CHENNAI METROPOLITAN DEVELOPMENT AUTHORITY
Thalamuthu Natarajan Building, No.1, Gandhi Irwin Road, Egmore,
Chennai - 600 008
Phone : 28414855 Fax: 91-044-28548416
E-mail: mscmda@tn.gov.in
Web site: www.cmdachennai.gov.in

Letter No.C4/11060/2017

Dated : 06.11.2017

Sub: CMDA - Area Plans Unit - 'B' Channel Central Dn. -Planning Permission for the Proposed Construction of Basement floor (Grain Storage) + Ground floor (Grain storage, Restaurant & Shop) + First floor (Grain storage, Bank & Shop) + Second floor (Grain storage) Commercial building at Plot – B 164/1 pt, 2 pt, 3 pt, 165 pt, 166/2 pt, 180/1 pt, 2 pt, 3 pt, T.S.No.8 pt, Block No.37, T.S.No.1 pt, 2/1 pt Block No.38 of Koyambedu village, Chennai.- Development charges to be remitted – Reg.

SITE PLAN

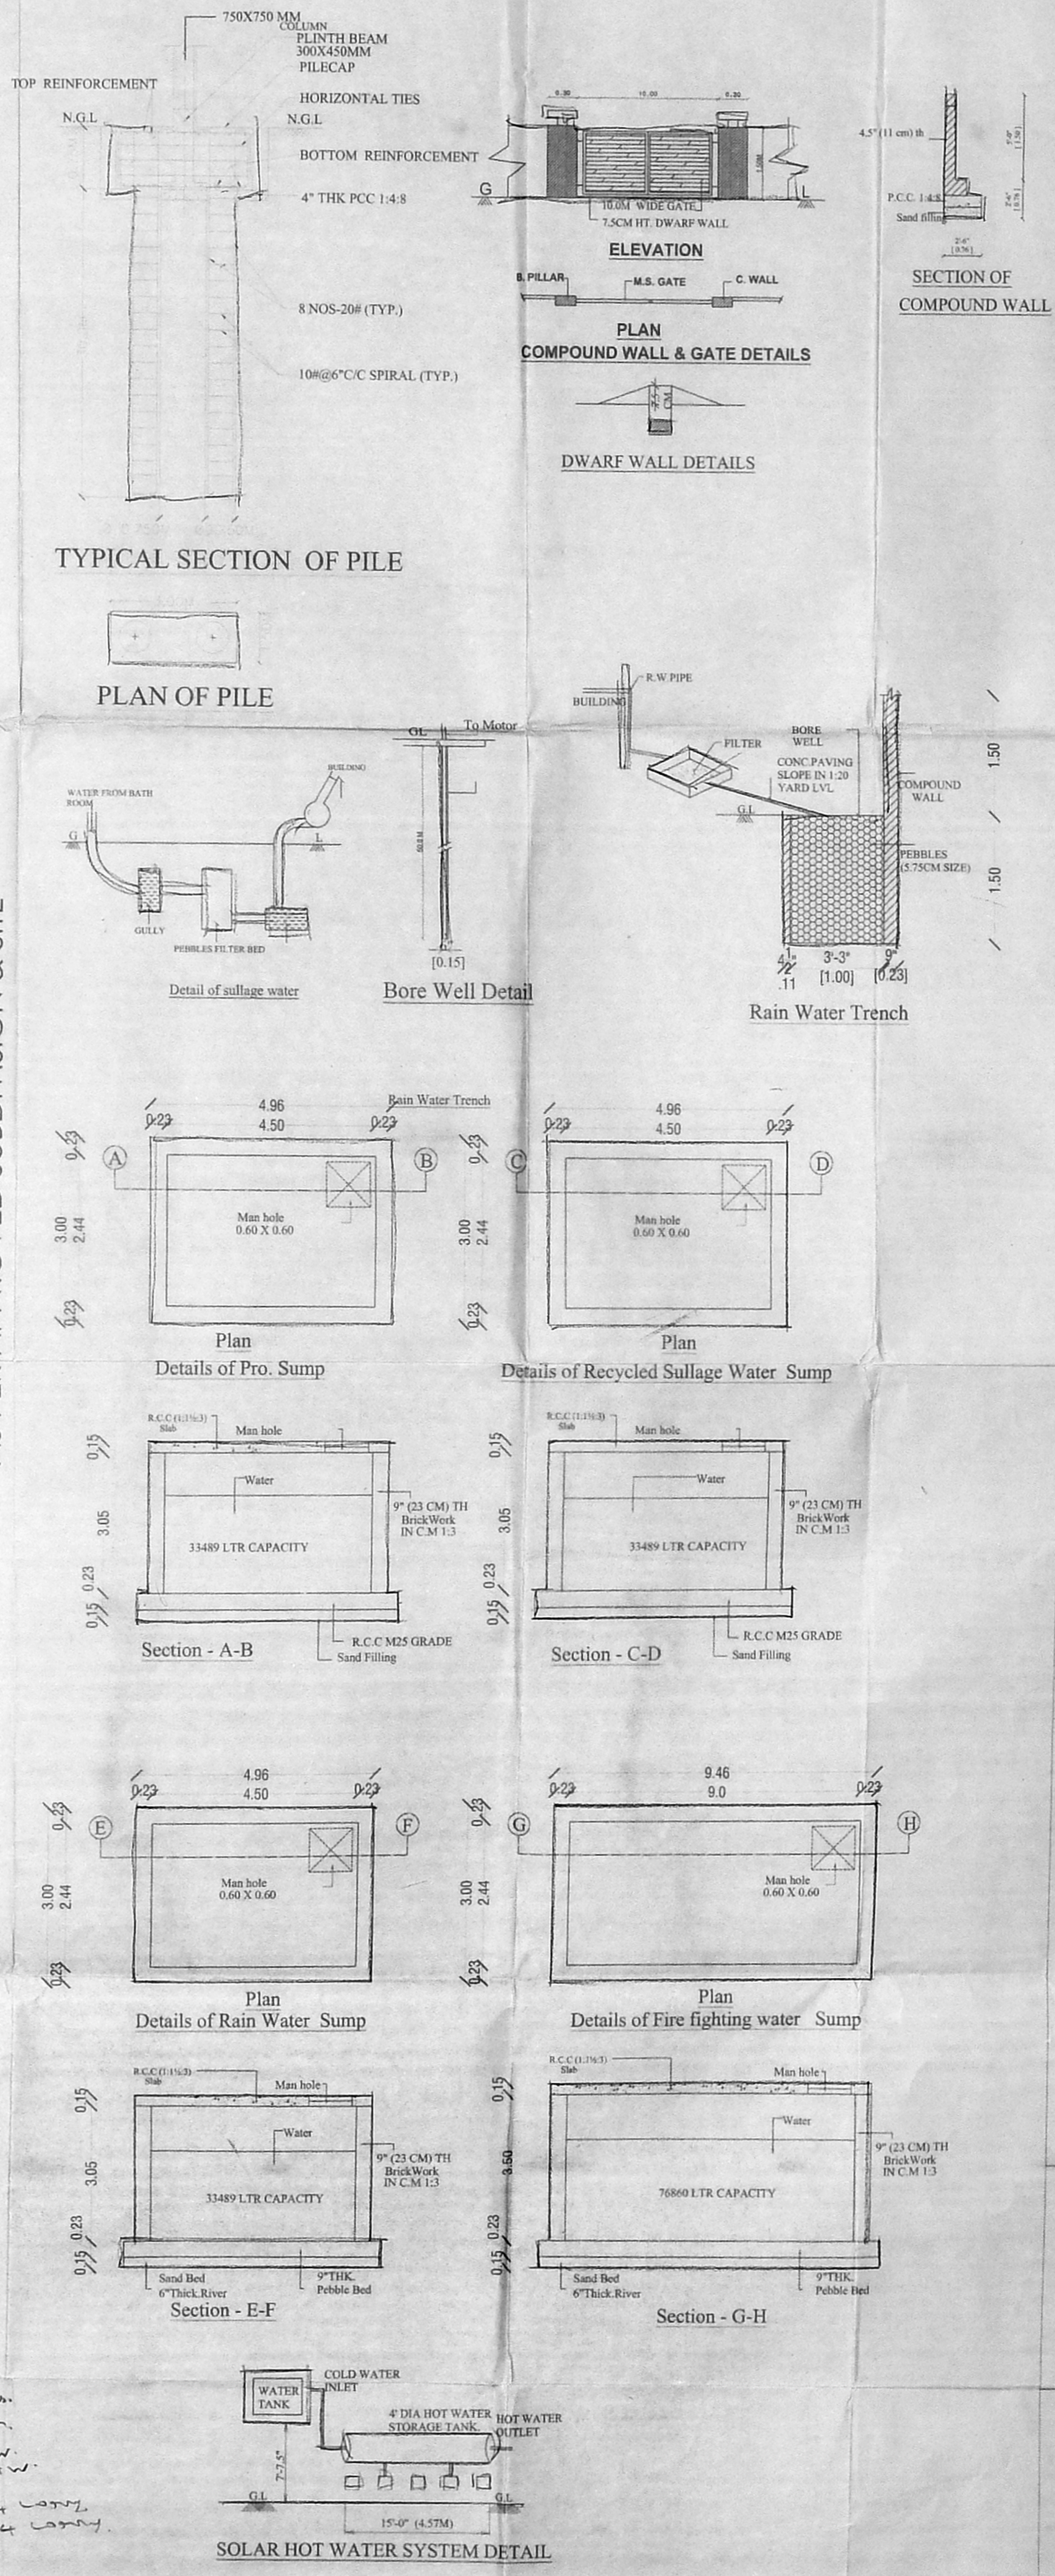
- i. Site boundary measurements to be shown as per approved sub division plan.
- ii. External Fire escape staircase to be provided as per NOC issued by DF & RS
- iii. As per NOC issued by DF & RS U.G. Sump for a capacity of 70,000 liters to be provided.
- iv. Required lorry parking 14 Nos provided 10 Nos. less by 4 nos. and parking to be rearranged.
- v. PP1 and PP2 to be furnished in the prescribed format and incorporating profile of the building and its usage.
- vi. Under taking to be furnished to comply the conditions as mentioned in the NOC issued by CMRL and DF & RS
